Markup Summary

Subject: Text Box
Page Label: 1
Author: Lindsay Darden
Date: 6/12/2019 2:57:13 PM
Color: ■

SITE PLAN
 SCALE: 1"=30'-0"

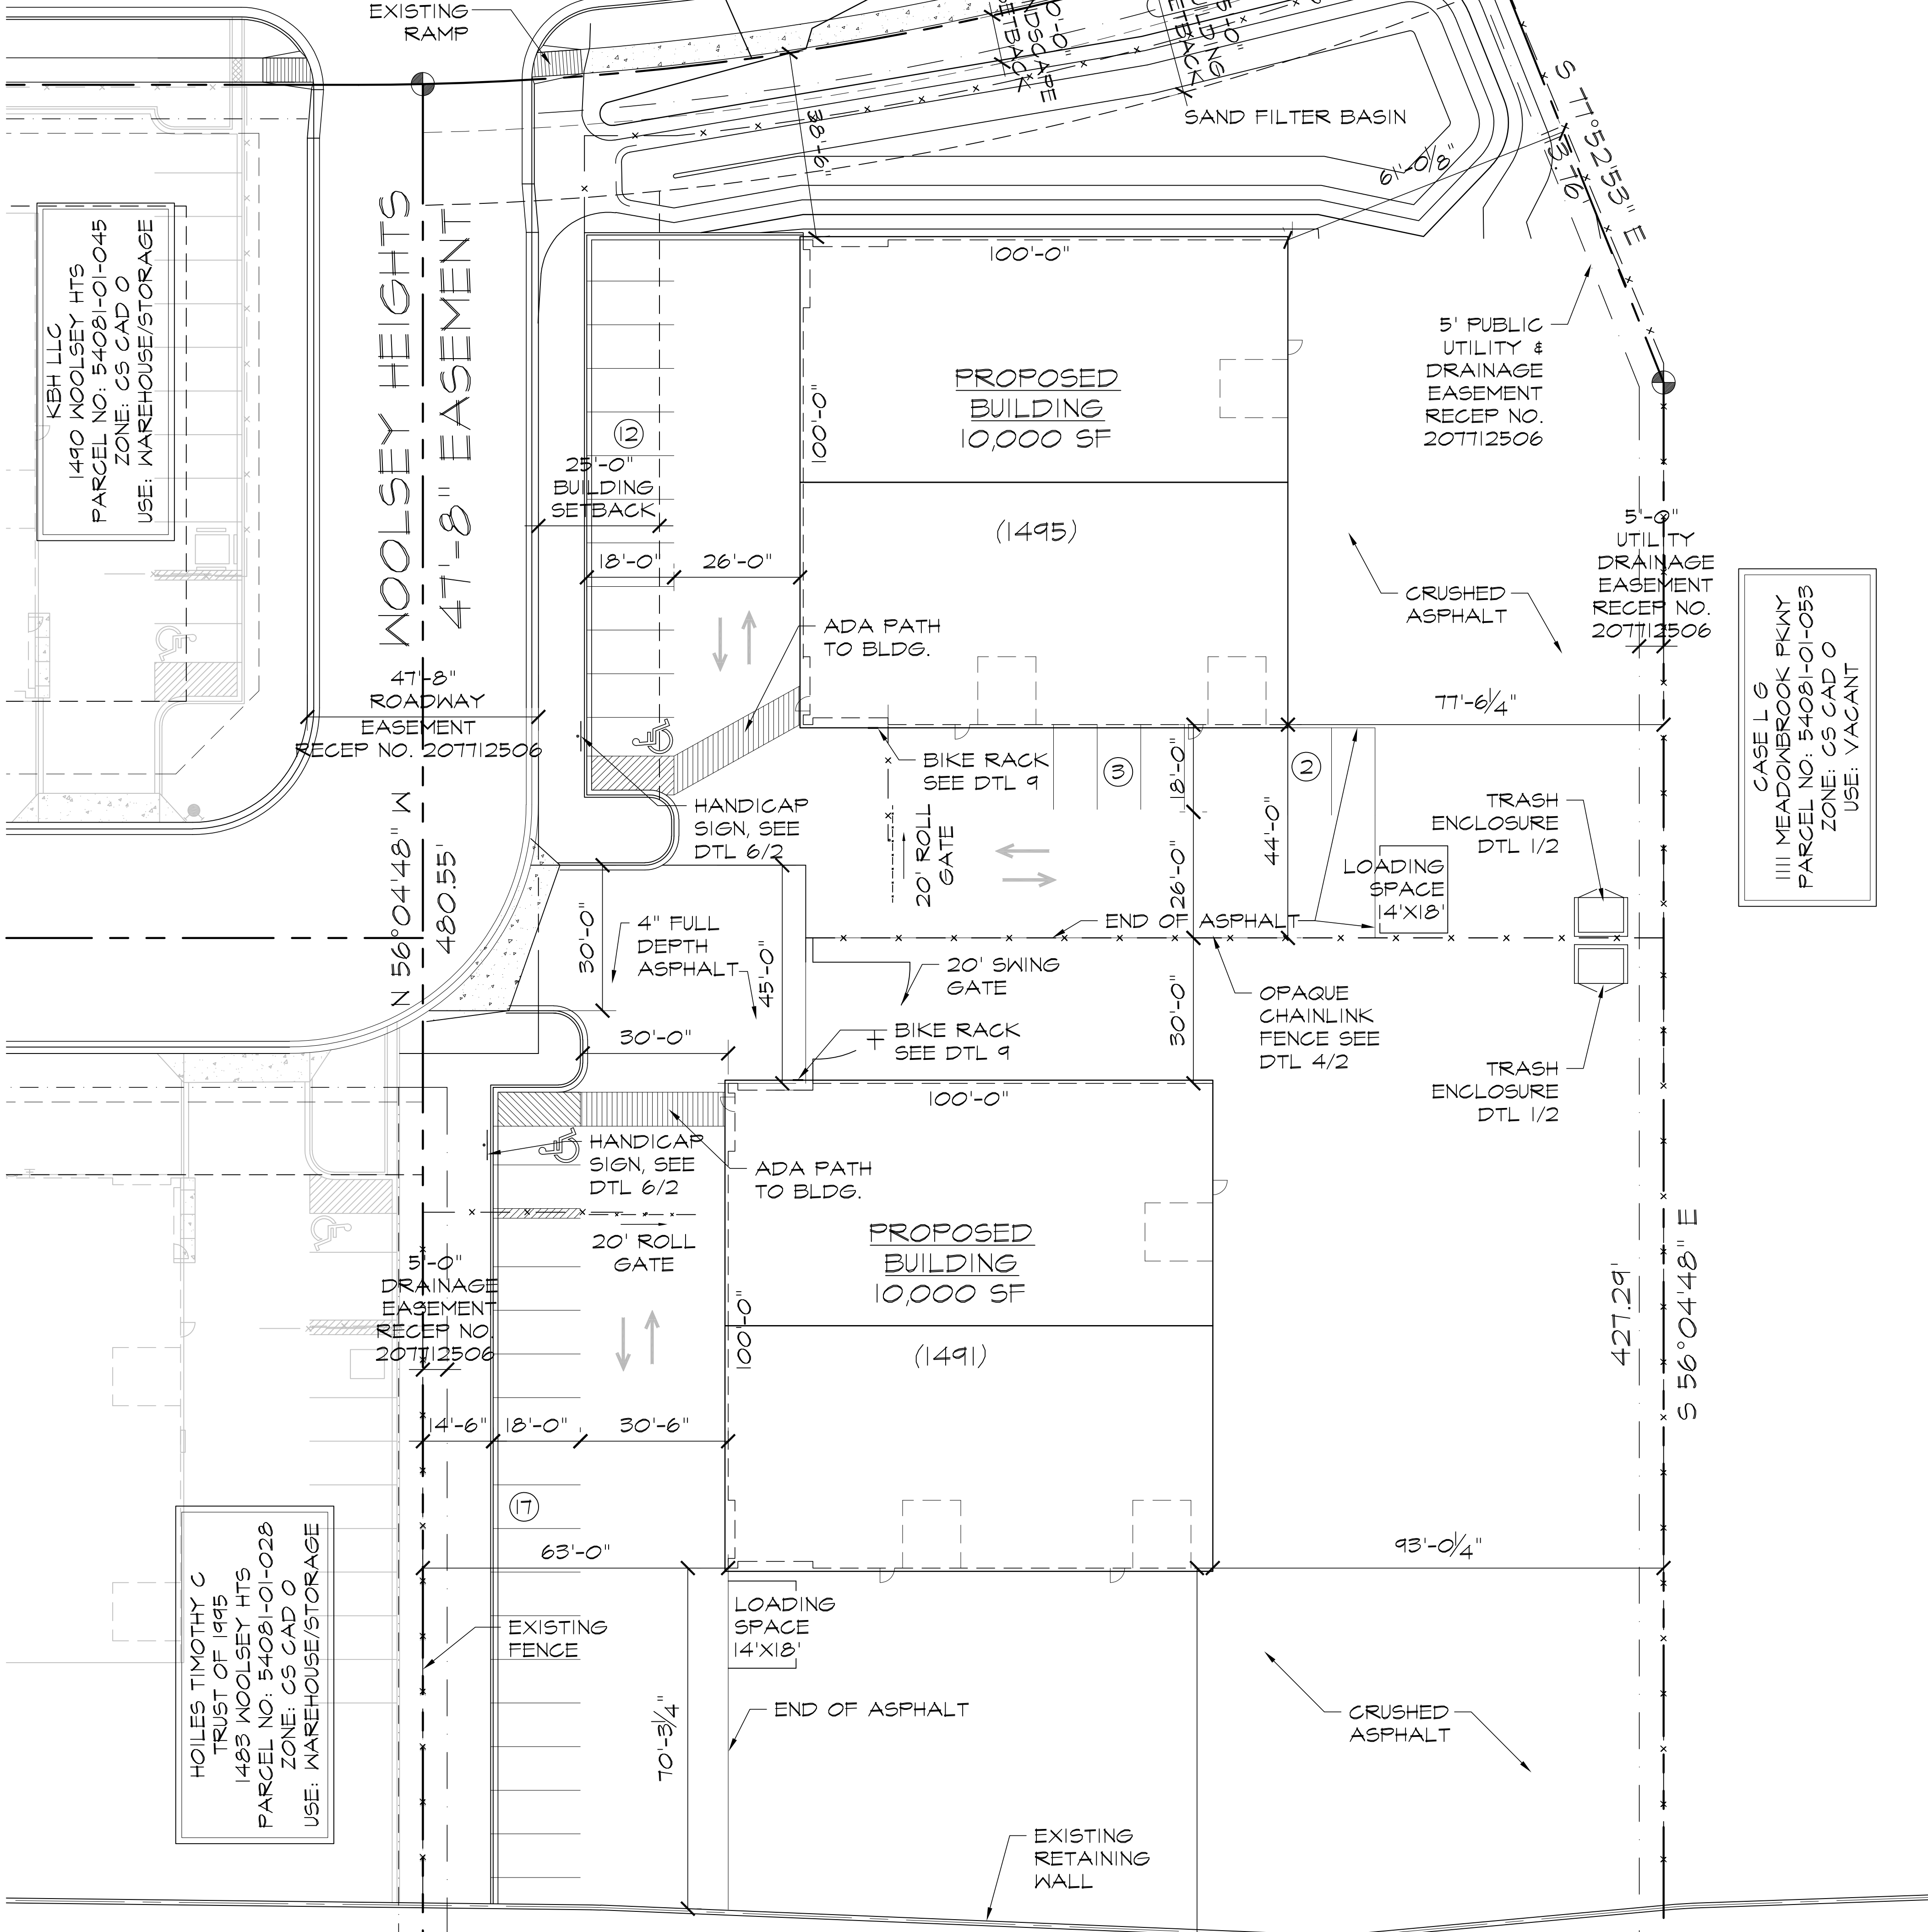
Repeat comment: Site distance triangles are still not labeled at intersections and driveways.

Repeat Comment: Label is still incorrect for # of parking spaces based on what is graphically shown.

Repeat Comment:
Roadway landscaping is required per LDC 6.2.2(B) along the lot, parcel, or tract frontage between the road ROW, easement, or tract boundary and any building or use. Provide along the HWY 24 property line for next submittal.

Scale of landscape plan should be appropriate to show the screening of the refuse areas. Screening for those is required per LDC 6.2.2(G)
